CITY OF ALBUQUERQUE

September 1, 2016

Re: Gonzalez Residence
2100 Edna Ave NW
Traffic Circulation Layout J13D081
Engineer's Stamp 08-23-16 (J13D203)

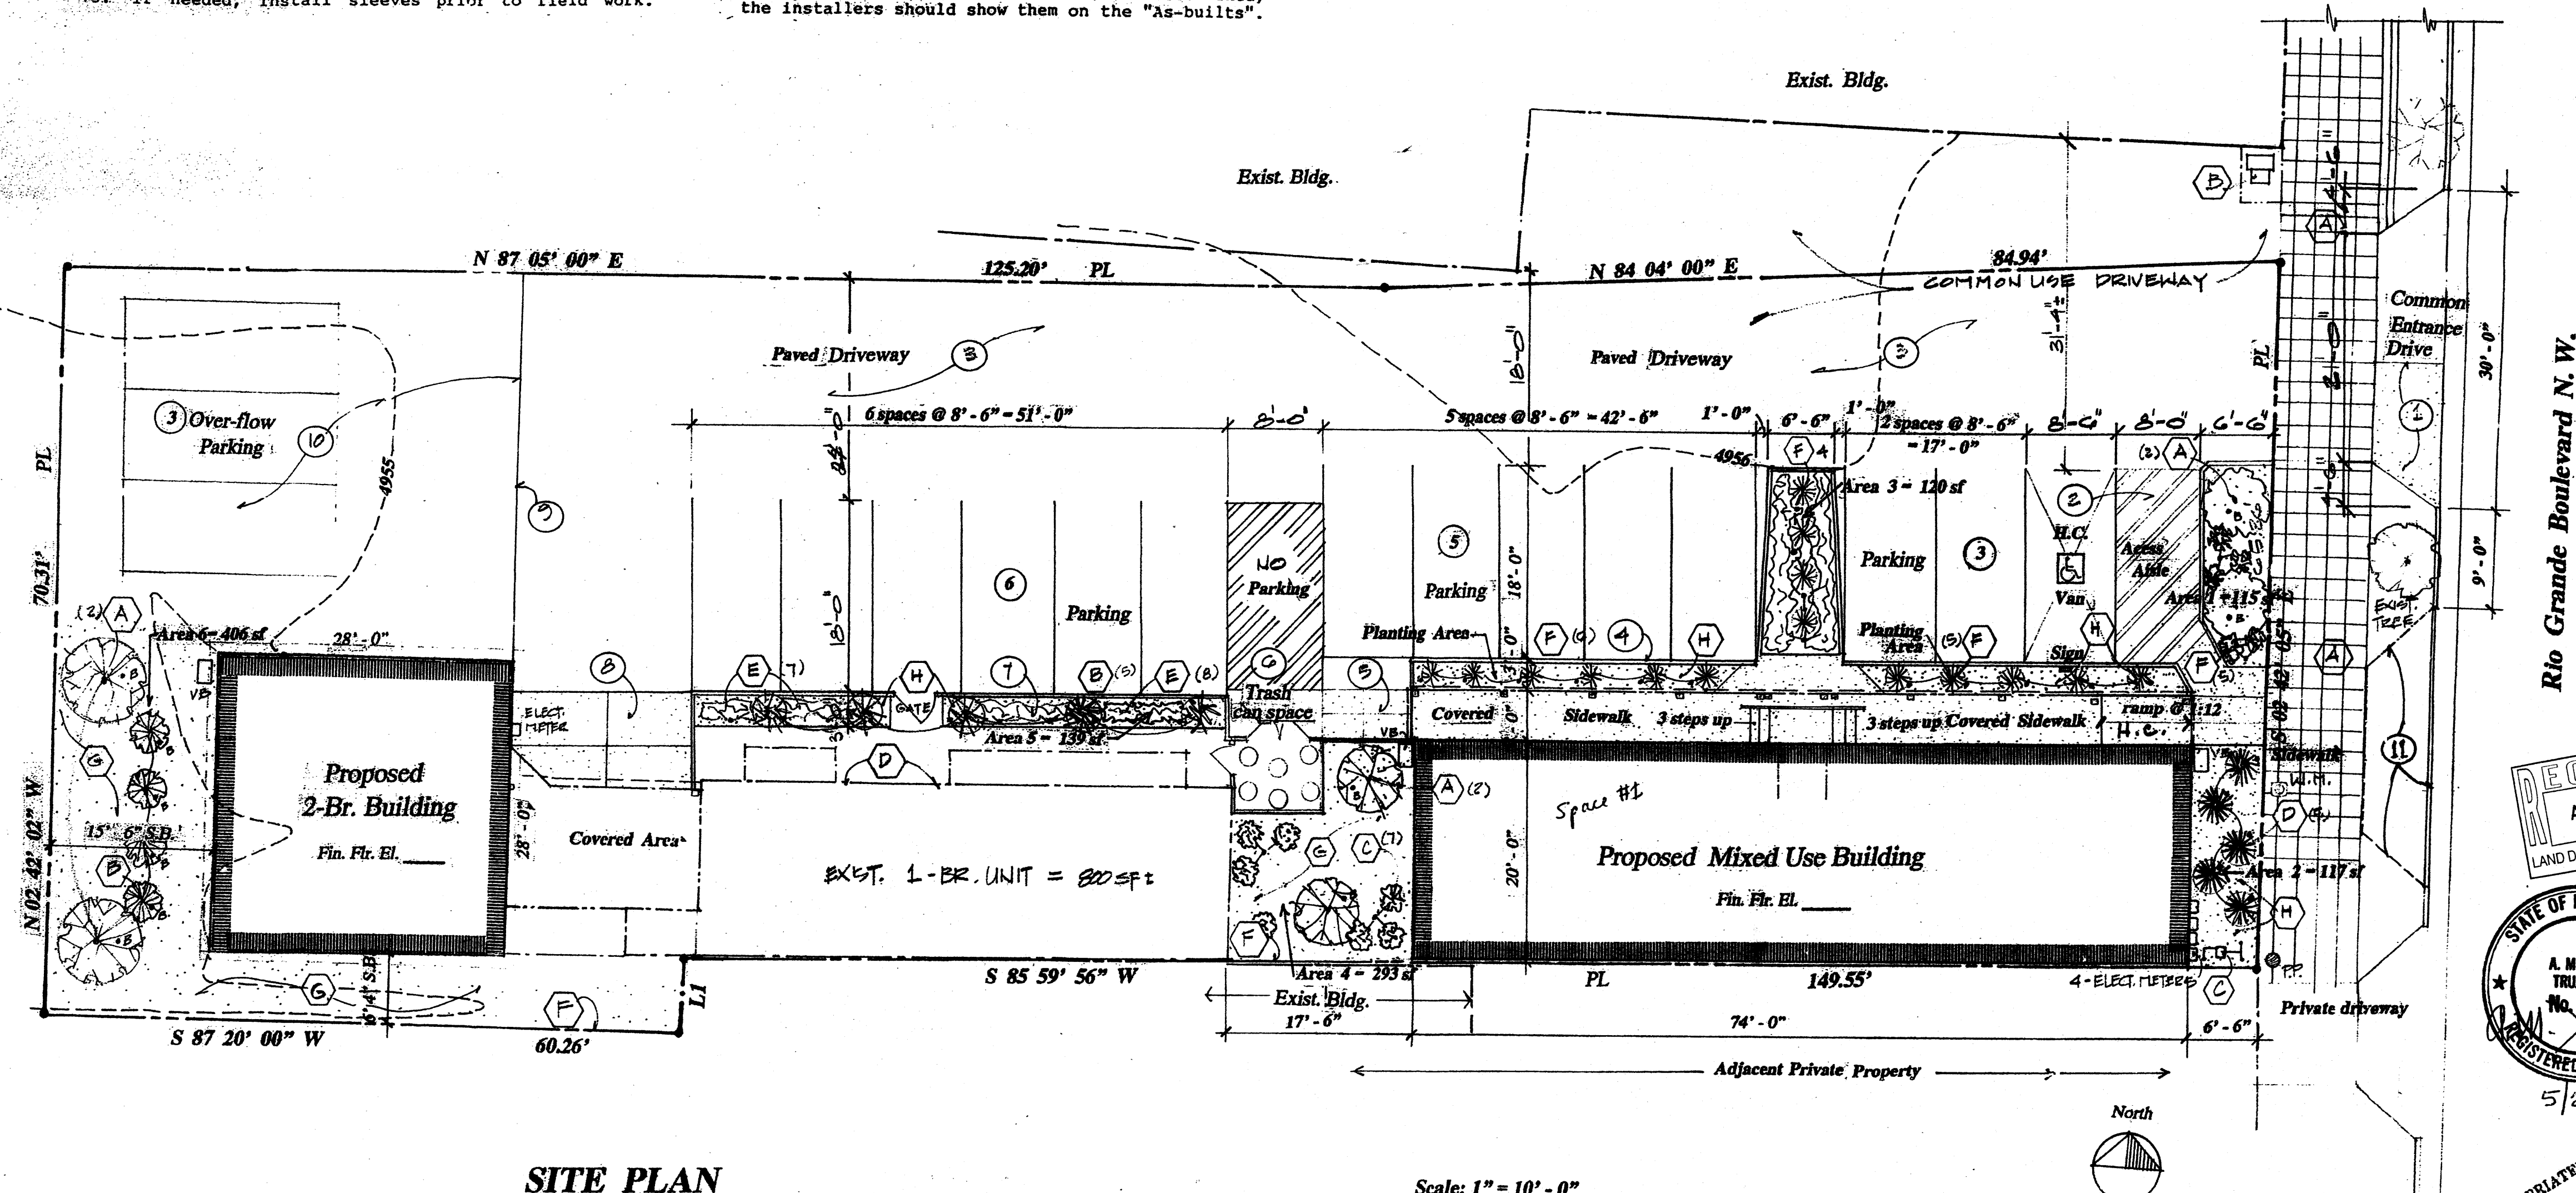
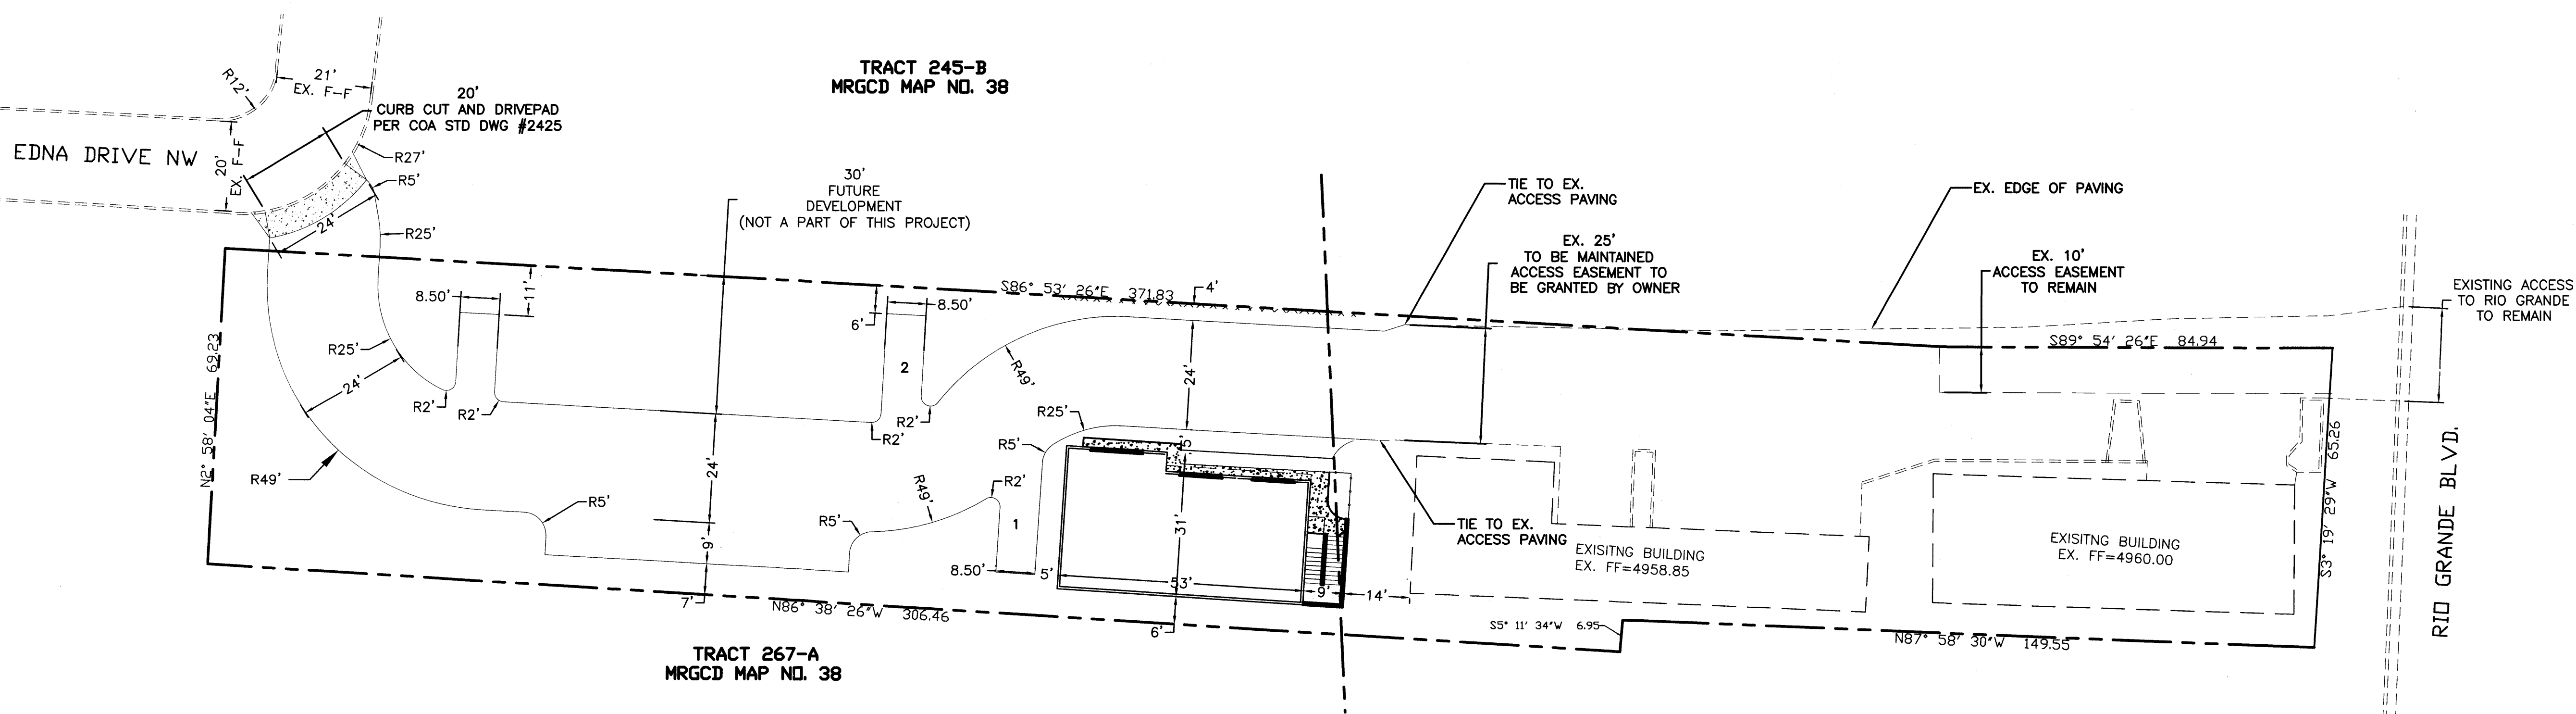
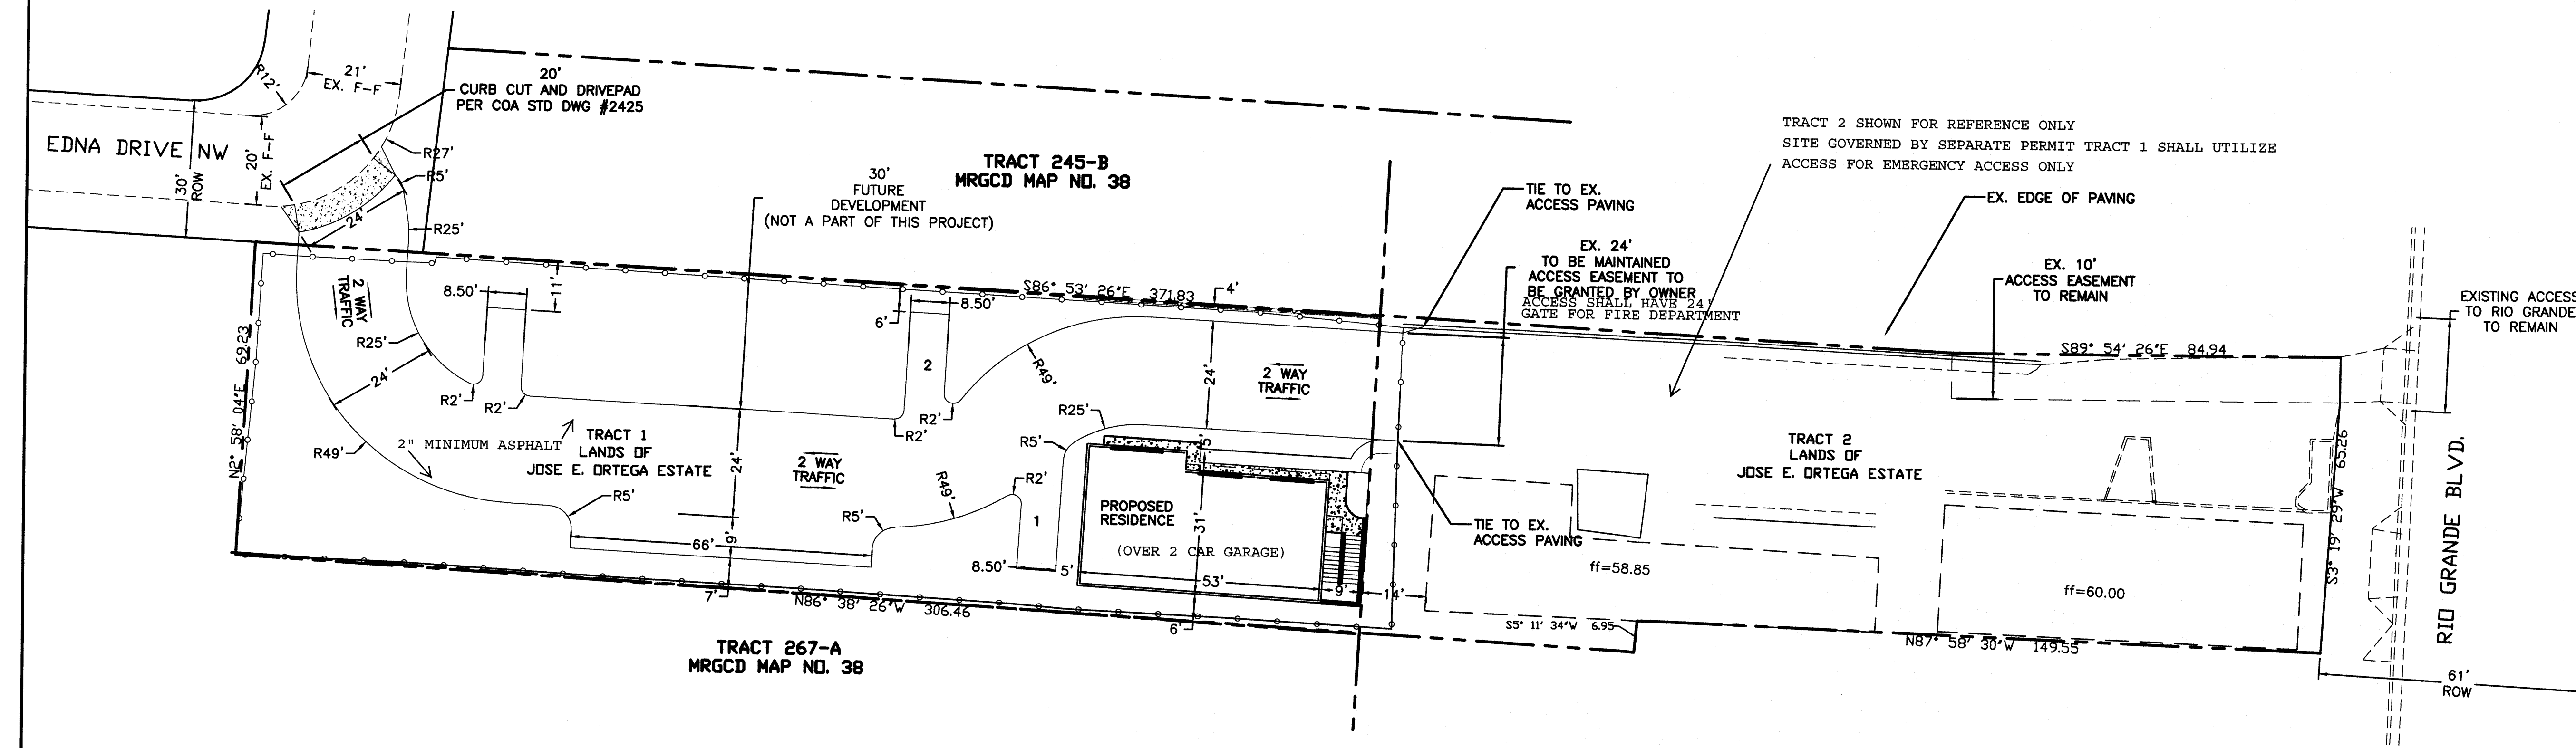
1. Please review and revise plan to provide all information listed on the attached Traffic Circulation Layout checklist.
2. Please refer to the attached Accessible Parking Checklist and revise the plan accordingly.
3. If the existing approved TCL dated 05-28-2014 is being revised please indicate how.
4. Access to this site from Edna Ave is denied.
5. Please include two copies of the traffic circulation layout at the next submittal.
